**From:** Simon Davis  
**Sent:** 31 January 2018 10:06  
**To:** 'Paul Spratt'  
**Cc:** 'Tim Townsend'  
**Subject:** RE: Sheffield Stand design details

I have discussed with my Team Leader and we do not consider that the building can be enlarged as it would deviate from the size shown on the approved planning layout and the size increase could not be considered as an NMA. Therefore, we will allow the compromise option 2 which although slightly larger is within NMA tolerances.

REFUSE AND CYCLE STORE FOR APARTMENT BLOCK 1:50

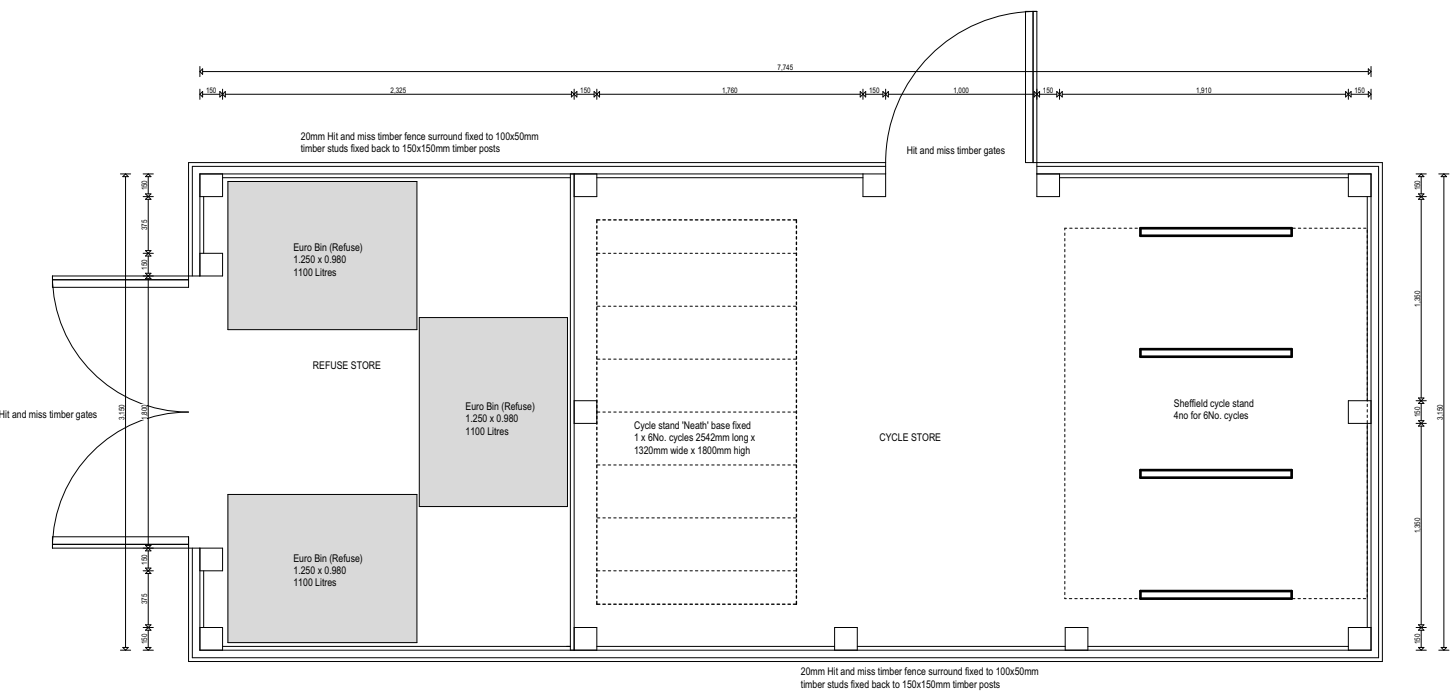
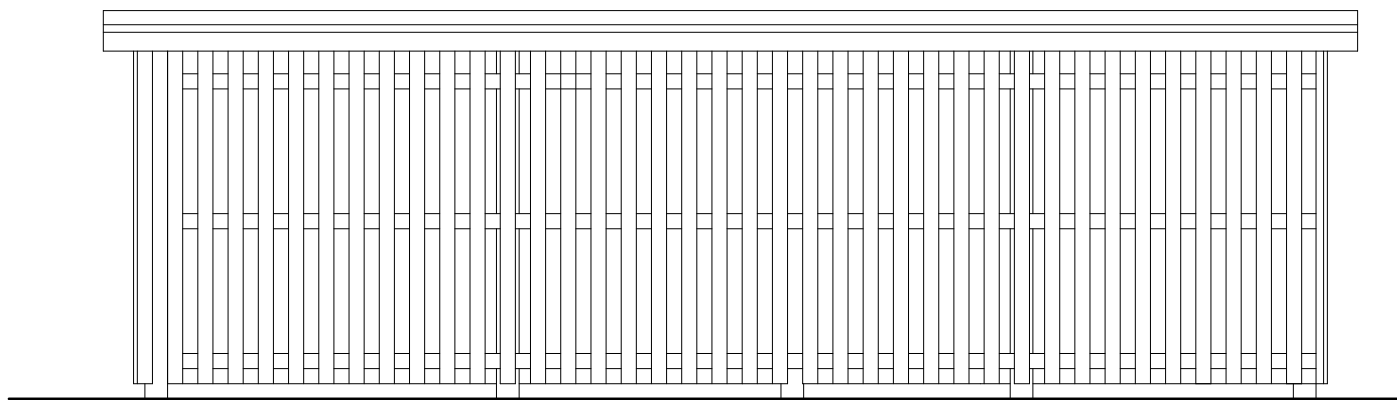
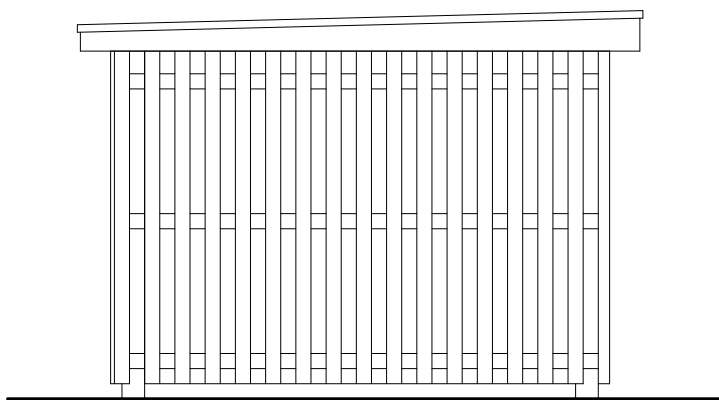
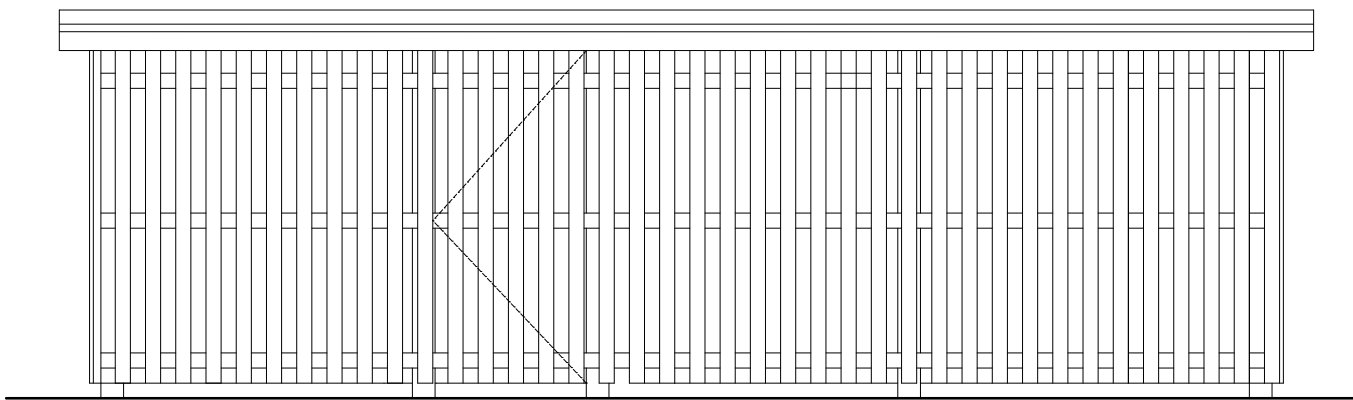
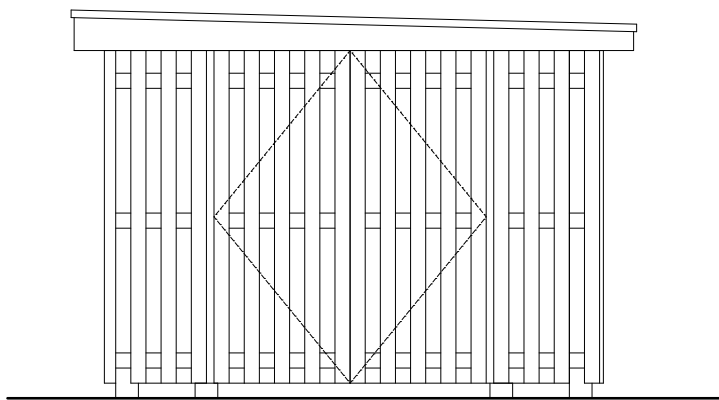
Please provide the drawing (plan & elevations for the option 2 design) so these can be added to the file.

Can you mock up some drawings as to how the larger store will appear and email them back to me so I can assess whether the larger building would be visually acceptable.

Ideally, I'd say enlarge the cycle store and provide the Sheffield stands. However, if the Planning Case Officer doesn't want it enlarged, a compromise could be considered. So, if Simon wants the building to stay as it is, then on this occasion I will accept the proposal as shown in your option 2 (so half Sheffields and half Neaths). However, if he's happy for it to be made bigger, go for all Sheffields.
